CITY OF PORTLAND

BUILDING PERMIT

Job ID: 2011-06-1477-ALTR

has permission to build a 15 foot X 15 foot deck.

MORTGAGE INSPECTION OF: DEED BOOK 7239 PAGE 32 COUNTY Cumberland
PLAN BOOK 147 PAGE 02 LOT 55

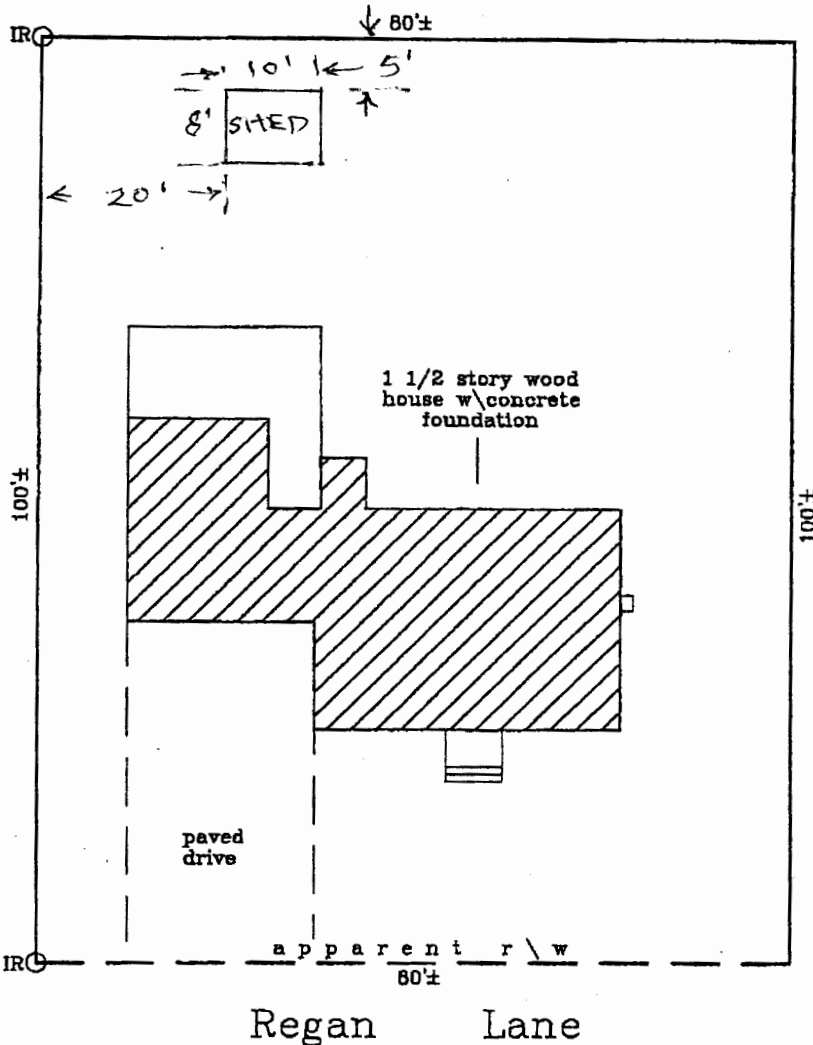
1. This permit is being approved on the basis of plans submitted. Any deviations shall require a separate approval before starting that work. It is further understood that the side setback is 12 feet to the side property line and 25 feet to the rear property line.
2. This is NOT an approval for an additional dwelling unit. You SHALL NOT add any additional kitchen equipment including, but not limited to items such as stoves, microwaves, refrigerators, or kitchen sinks, etc. without special approvals.
3. Separate permits shall be required for future decks, sheds, pools, and/or garages.
4. This property shall remain a single family dwelling. Any change of use shall require a separate permit application for review and approval.

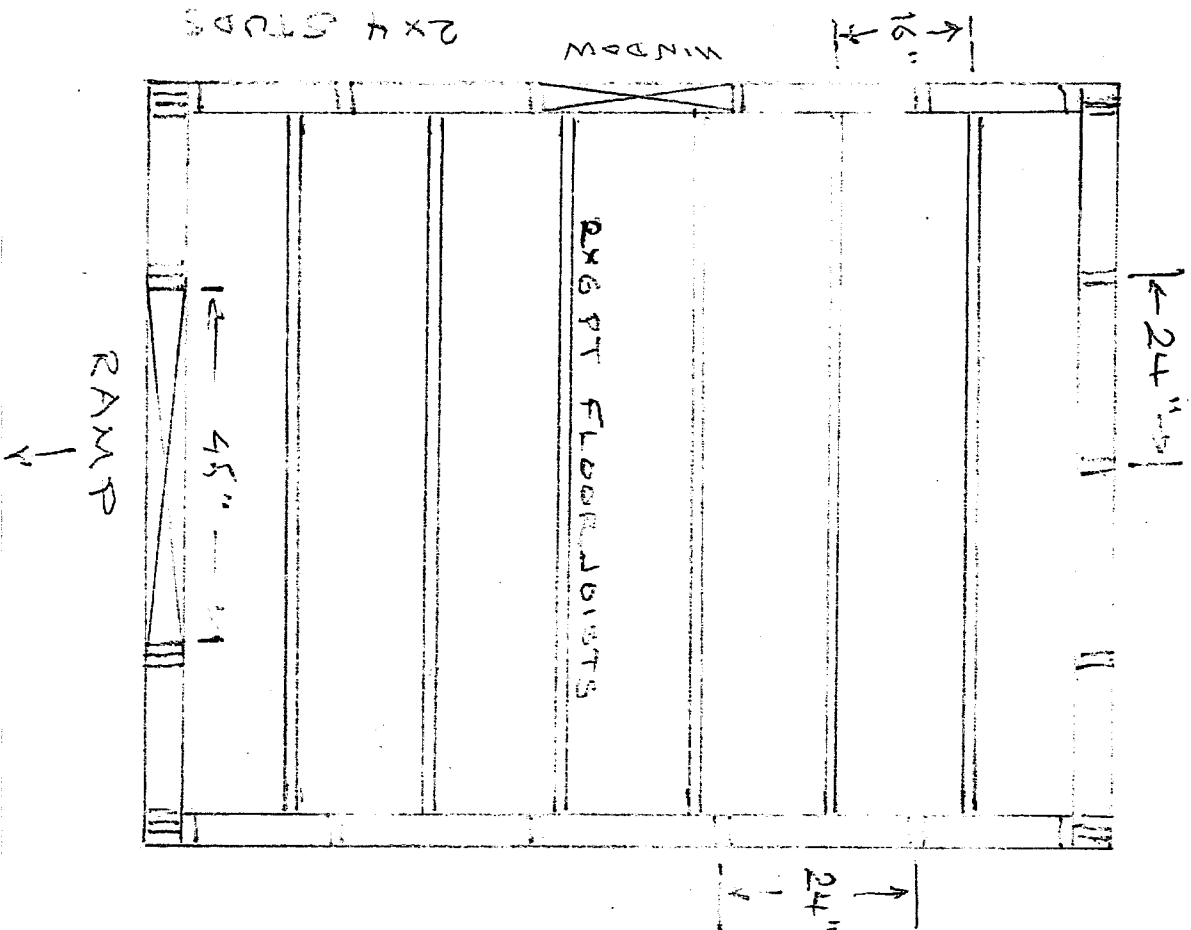
1. Frost protection must be installed per the enclosed detail as discussed w/owner/contractor (at least 4' from grade).
2. A graspable handrail (34-38 inches in height) shall be provided on at least one side of each continuous run of treads or flight with four or more risers. Fall protection (36 inches) from exterior decks may be required if floor joist are at or above thirty (30) inches from grade.

3. R311.5.1 Attachment. Exterior landings, decks, balconies, stairs and similar facilities shall be positively anchored to the primary structure to resist both vertical and lateral forces or shall be designed to be self-supporting. Attachment shall not be accomplished by use of toenails or nails subject to withdrawal.

5. **R502.6 Bearing.** The ends of each joist, beam or girder shall have not less than 1.5 inches (38 mm) of bearing on wood or metal and not less than 3 inches (76 mm) on masonry or concrete except where supported on a 1-inch-by-4-inch (25.4 mm by 102 mm) ribbon strip and nailed to the adjacent stud or by the use of *approved* joist hangers.

6. **Note:** The (2) 2 X 10 inch beam max span is 7 foot 3 inches between each 10 inch concrete "Sona tube".
